**WEST SUSSEX COUNTY COUNCIL
STRATEGIC PLANNING CONSULTATION**

SUBJECT: LU/234/16/RES - Application for reserved matters relating to access, appearance, landscaping, layout and scale of the previously approved LU/63/11/. This application affects a Public Right of Way.

LOCATION: Fitzalan Link Road, Worthing Rd (A259), East Street, Littlehampton, West Sussex.

This is the third WSCC highways and transport response to the above planning application. It follows submission of further information from the applicant's Highway Consultant (Mayer Brown) in the form of the following in response to comments made in previous WSCC highways reports dated 21st September and 21st October 2016:

| title  | PUBLIC RIGHT OF WAY DIVERSION PLAN |

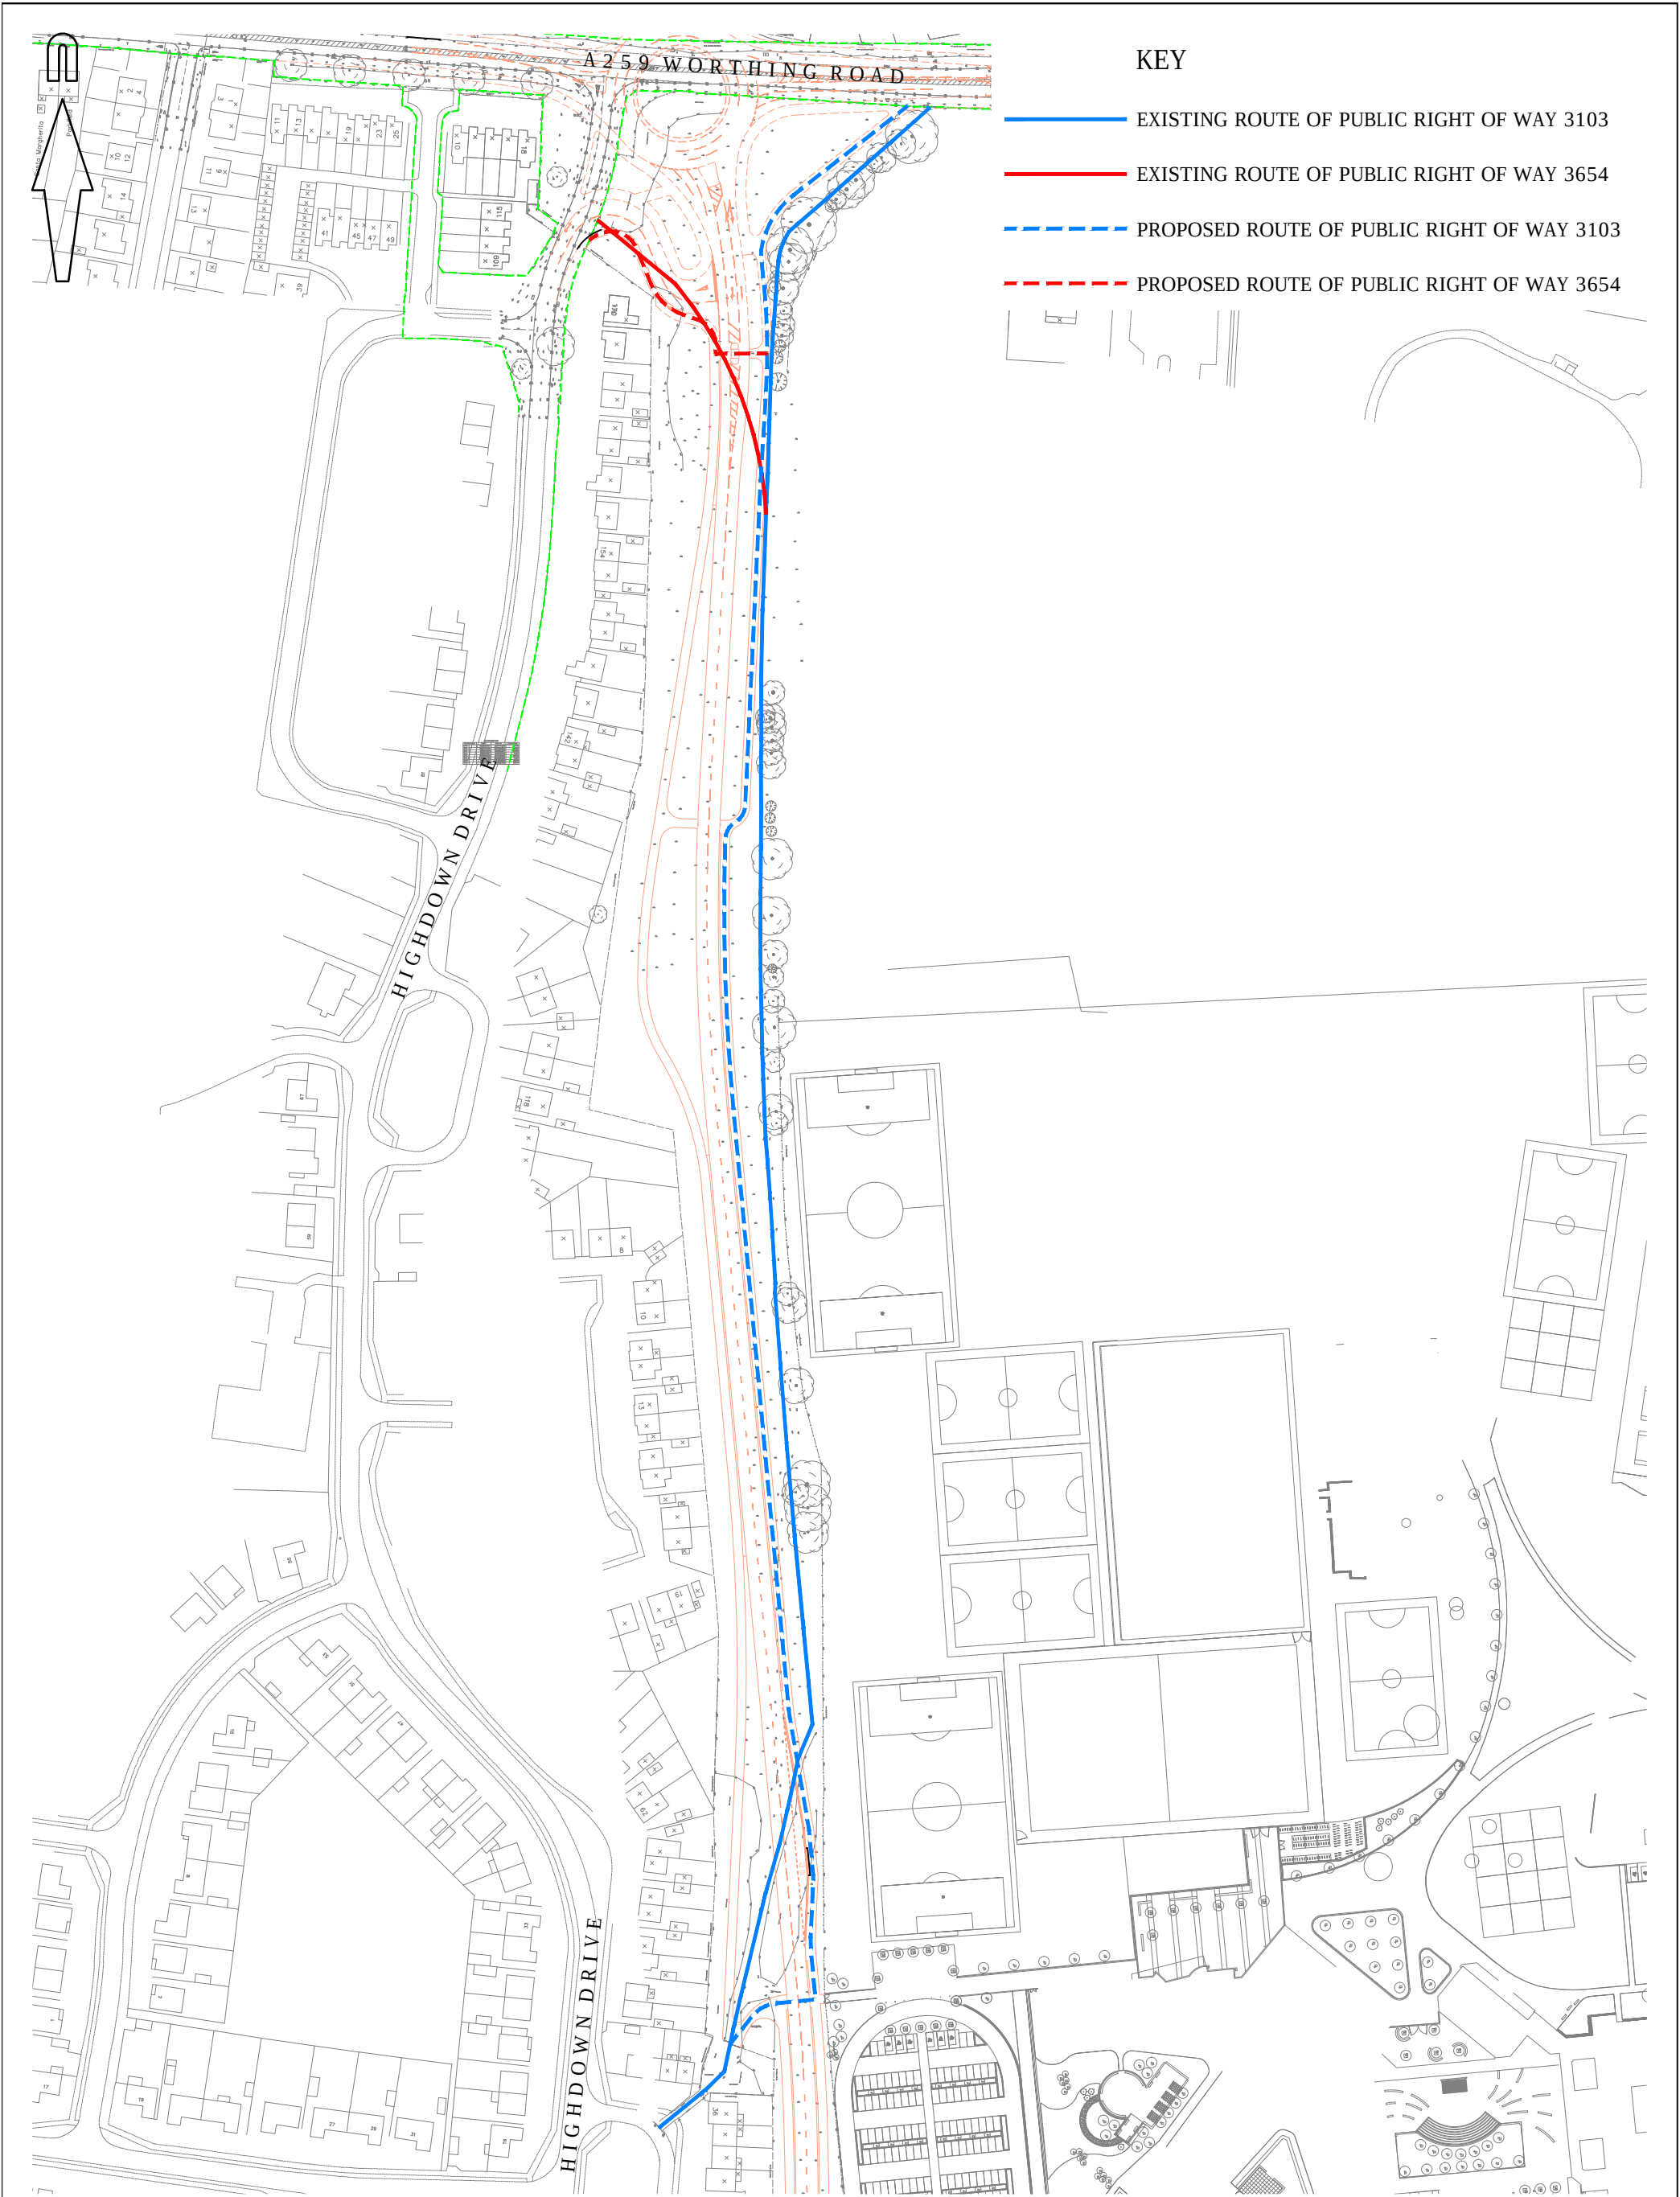
1. Red line boundary – This has implications for PRow connection in south-western corner (north of Academy roundabout) – please demonstrate that an appropriate design can be accommodated and correctly interact with existing PRow connection. As shown, the existing path and the new paths do not appear to tie-in. Also see 3 below. **Further information and alterations required.**

3. Shared footpath/cycleways alongside both sides of the access road – On the western side at the point the PRow joins the scheme, the alignment is very convoluted and may not meet appropriate design standards. Please amend and remove bends etc. This also applies to the 'kink' on the eastern side of the road found further north. Also, because of the increased speed limit along the majority of the road, it is recommended that the footpath/cycleways be set-back from the edge of the carriageway by a minimum of 1.5m wherever possible. Also because of the speed limit, a signal controlled crossing should be provided in this location (Toucan). Any design should be Safety Audited before planning consent is issued. **Please provide amendments, Road Safety Audit and Designer's Response.**
